DEVELOPMENT REVIEW BOARD--SPEED MEMO

DRB CASE NO/PROJECT NO: 1004875 AGENDA ITEM NO: 6
	SUBJECT:
	Site Plan for BP Final Plat Preliminary Plat
	ACTION REQUESTED:
P.O. Box 1293	REV/CMT:() APP:(x) SIGN-OFF:() EXTN:() AMEND:()
Albuquerque	ENGINEERING COMMENTS:
	An approved Subdivision Improvements Agreement with financial guarantees is required for Site Development Plan sign-off.
New Mexico 87103	
vww.cabq.gov	RESOLUTION:
	APPROVED; DENIED; DEFERRED; COMMENTS PROVIDED; WITHDRAWN
	SIGNED-OFF: (SEC-PLN) (SP-SUB) (SP-BP) (FP) BY: (UD) (CE) (TRANS) (PKS) (PLNG)
	DELEGATED: (SEC-PLN) (SP-SUB) (SP-BP) (FP) TO: (UD) (CE) (TRANS) (PKS) (LNG)
	FOR:
	SIGNED: Bradley L. Bingham City Engineer/AMAFCA Designee 924-3986 DATE: December 19, 2007

DRB CASE NO/PROJECT NO: 1004875 AGENDA ITEM NO: 6

Project #1004875, Religious Society of Friends-Quaker Church

A1 EXISTING SITE & CONCEPTUAL UTILITY PLAN  
1"=20'-0"

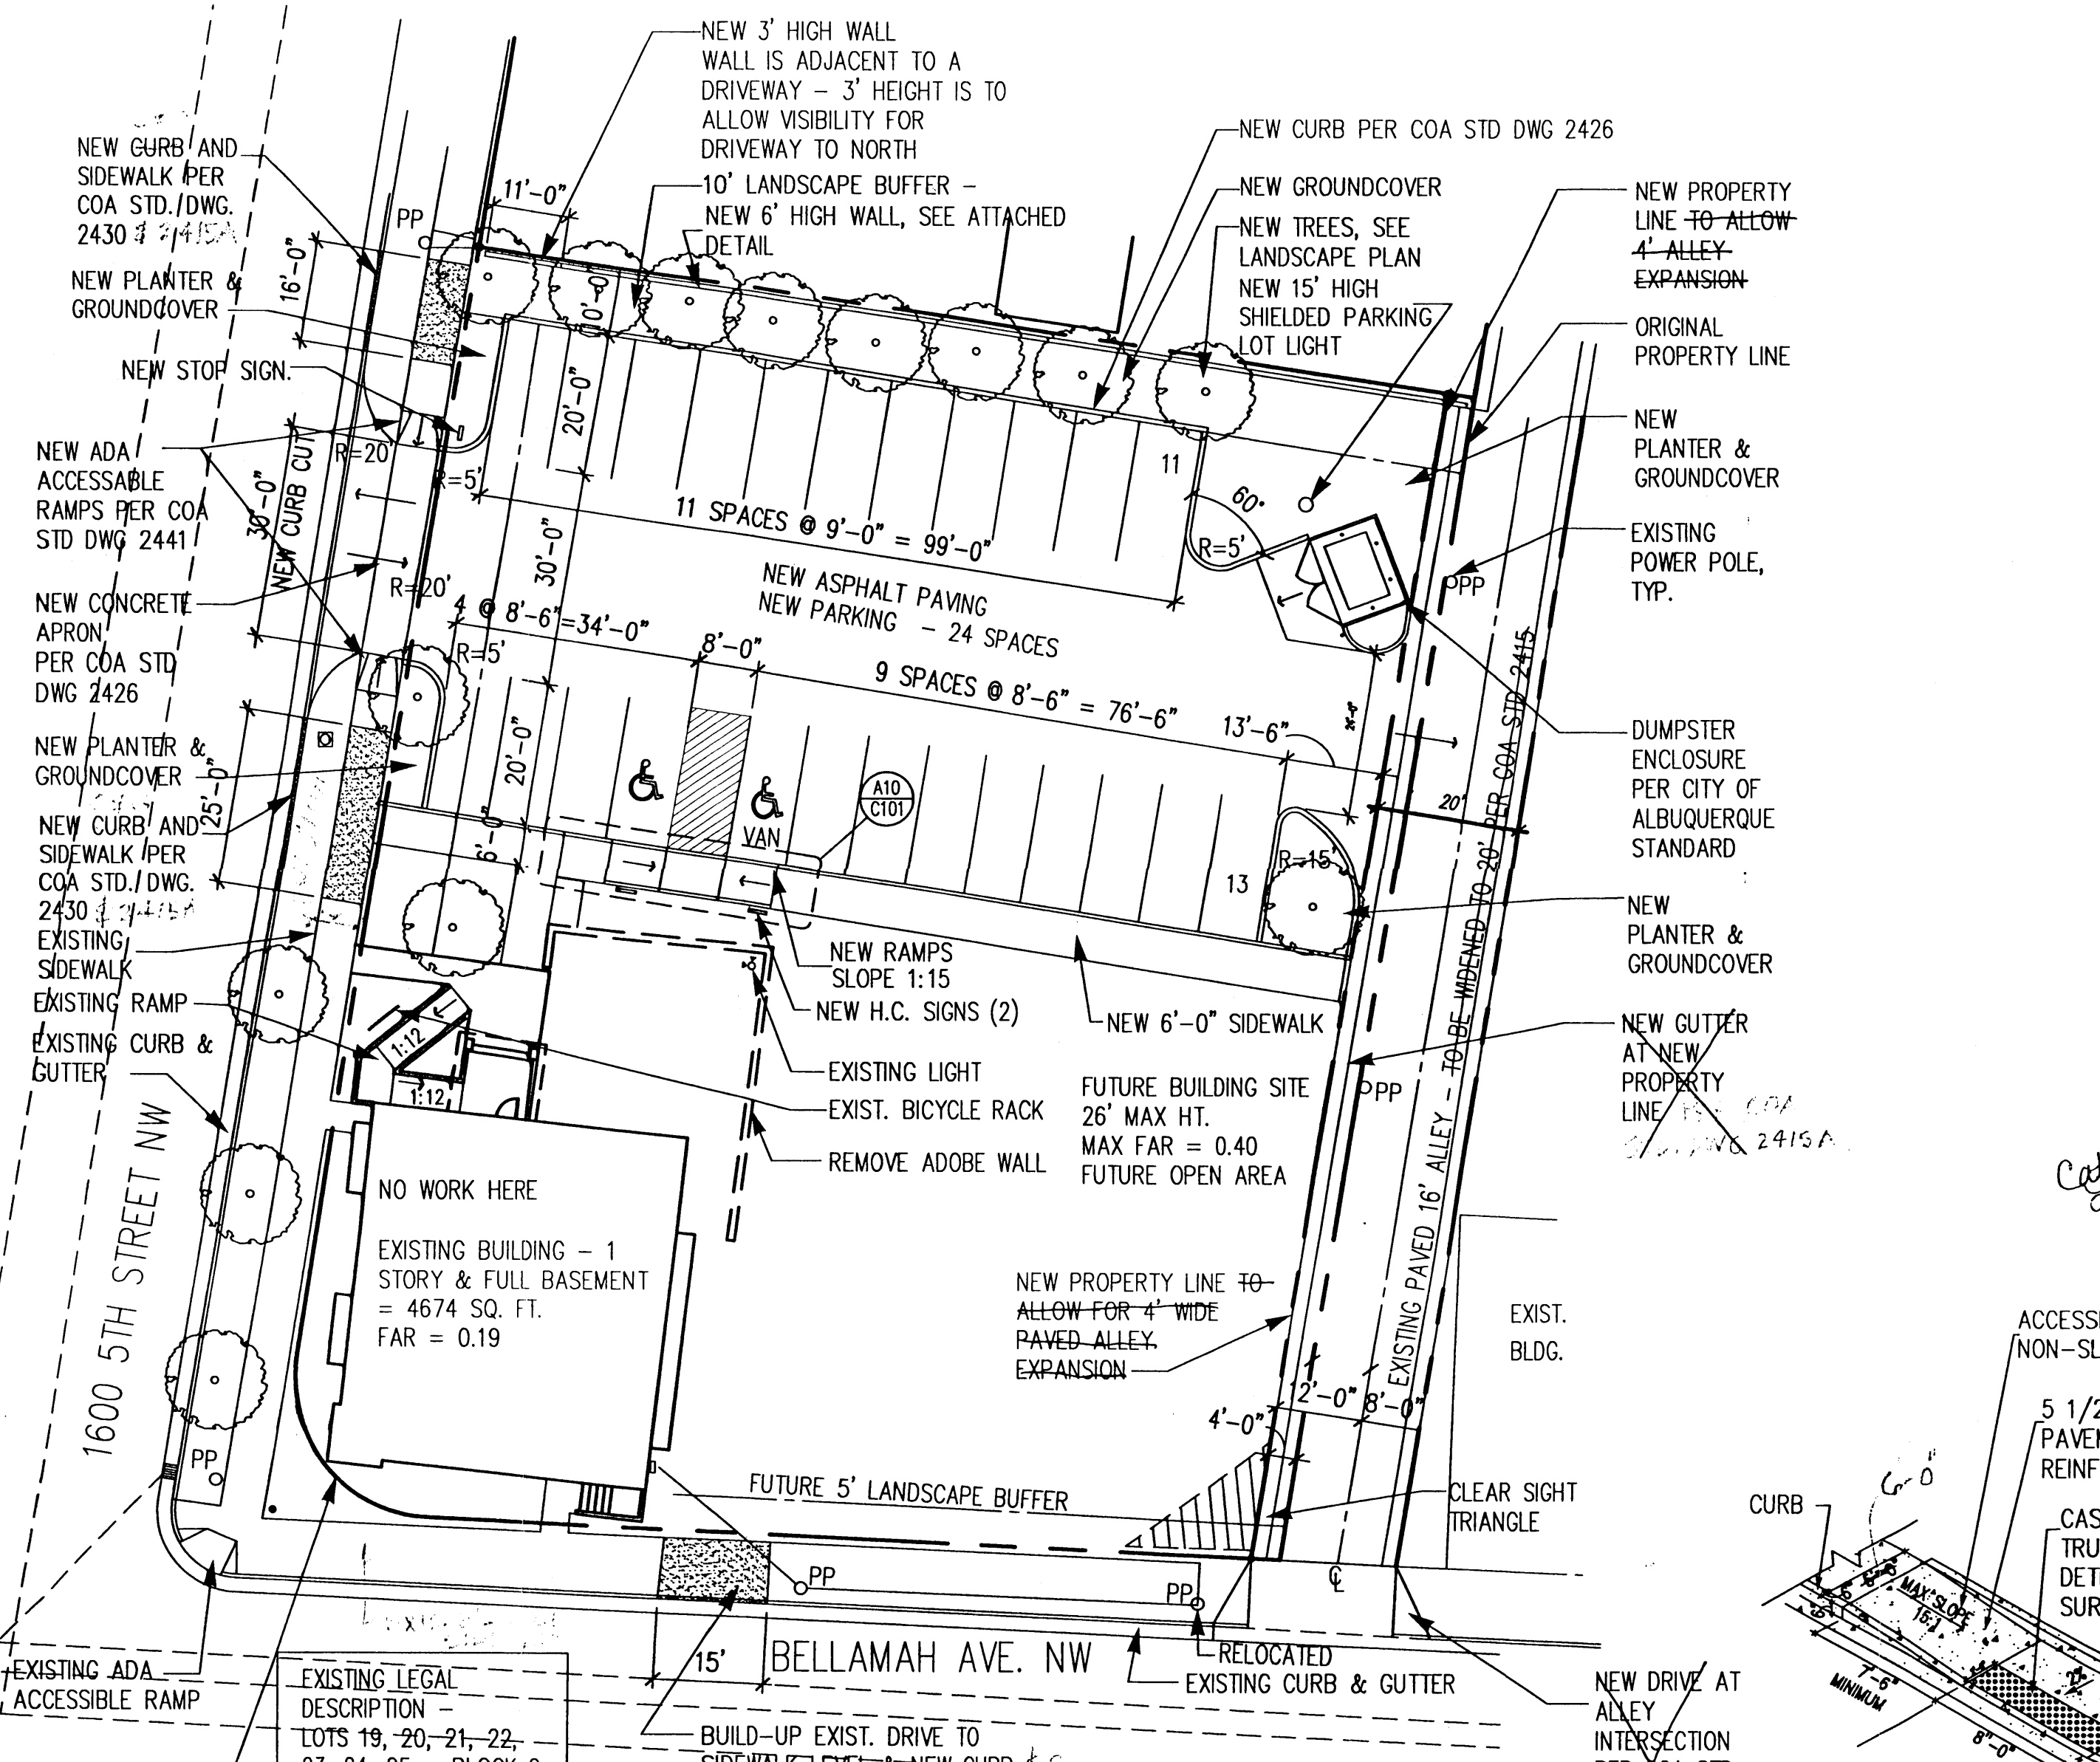
Call out the removal of all existing drivepads

Call out the removal of all existing drivepads

- 1. Removals of existing drive pads are called out on drawing A1/C101 and on Grading and Drainage Plan Sheet 1.
- 2. New alley entrance is shown on A7/C101.
- 3. Alley will be widened per CoA Standard 2415 and this is now stated on A7/C101.
- 4. Existing and proposed ramps:
 - a. Existing ramps in R.O.W. were constructed per City Standards.
 - b. Slopes of existing ramps on the site were added to A7/C101 to show compliance with ADA standards.
 - c. New ramps in R.O.W. will be constructed per CoA Standard Drawing 2441 and will meet ADA standards. This is indicated on drawing A7/C101.
 - d. A plan detail and section have been added for the new ramp on the site showing compliance with ADA standards. See A10/C101
- 5. All previous DRB comments have been addressed.

The alley entrance at Bellamah Avenue must be modified to accommodate the new alley width If the alley is being built with a typical alley section (CoA standard 2415), please state this on the site plan The site plan shows an additional 4-foot of right of way dedication; this must be shown on the plat

Build notes, referring to the appropriate City Standard, must be provided for all work proposed within the City right of way

The proposed drive located on 5th Street must be a minimum of 30 feet in width (no left turn access), or 36 feet (with left turn access)

The alley entrance at Bellamah Avenue must be modified to accommodate the new alley width

The proposed drive located on 5th Street must be a minimum of 30 feet in width (no left turn access), or 36

- 11. For compliance of all ramps with ADA standards, see #4 above.
- 12. Width of new drive on 5th Street is corrected to 30' (no left turn access).

A10 RAMP - ADA SPACE  
1/8"=1'-0"

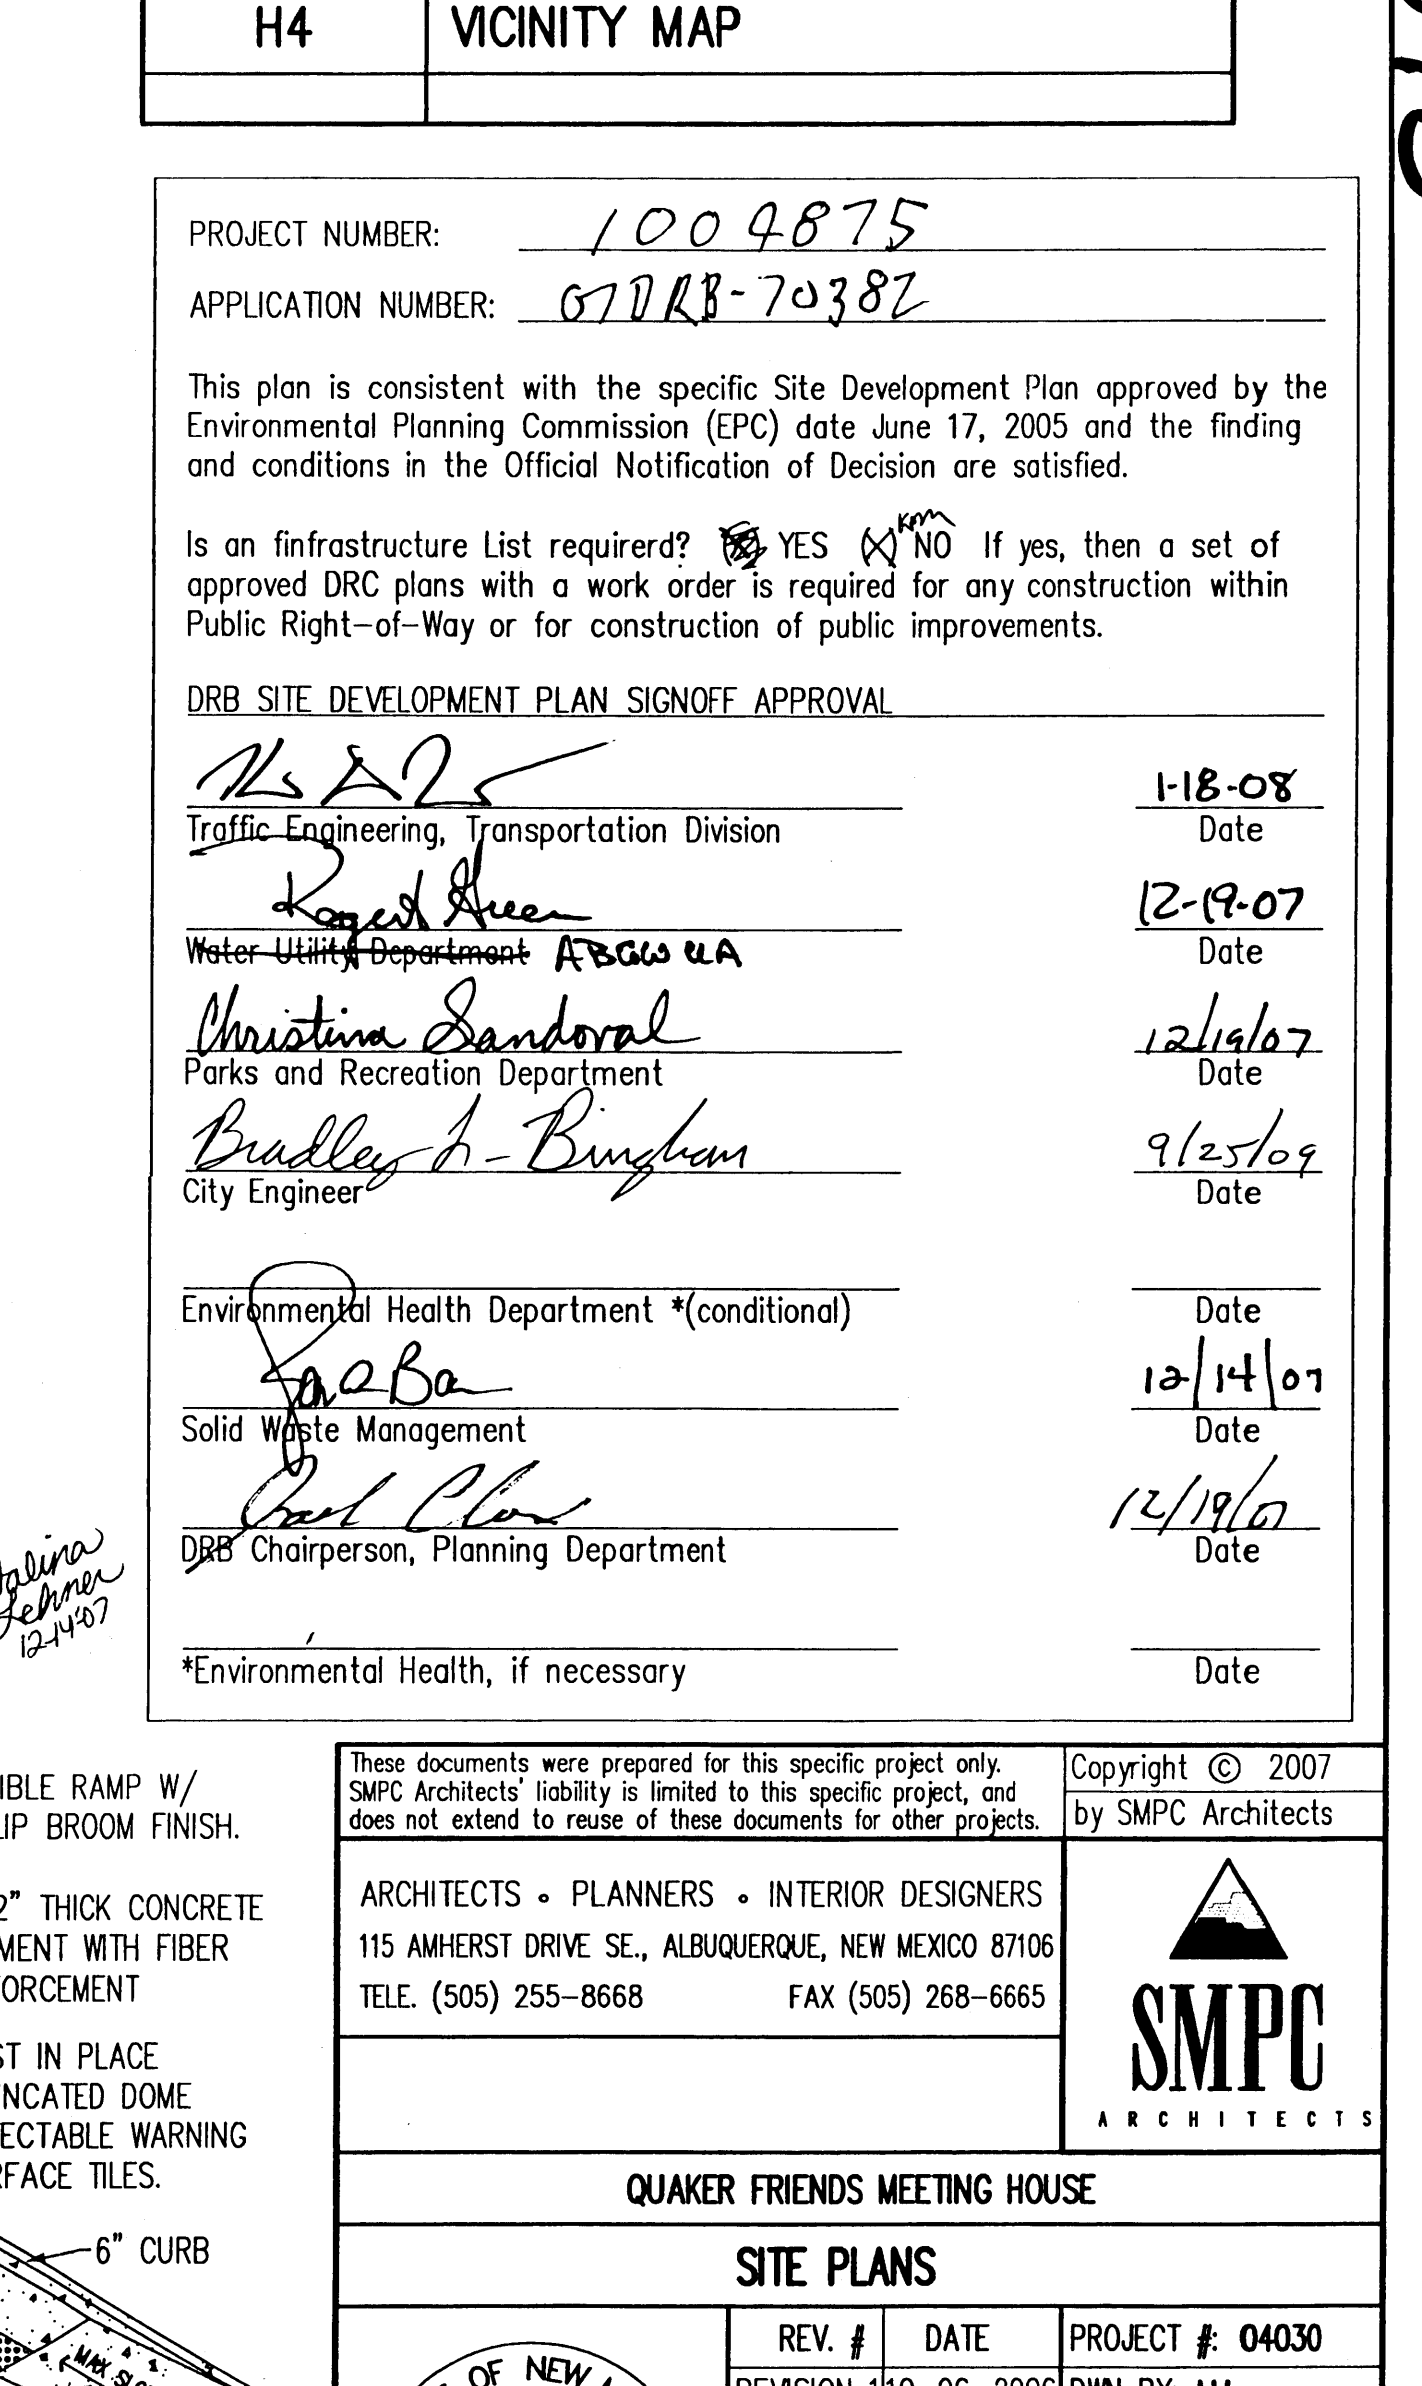
Show all ramps, both existing and proposed, and demonstrate how they meet current ADA standards; provide details

Show all ramps, both existing and proposed, and demonstrate how they meet current ADA standards;
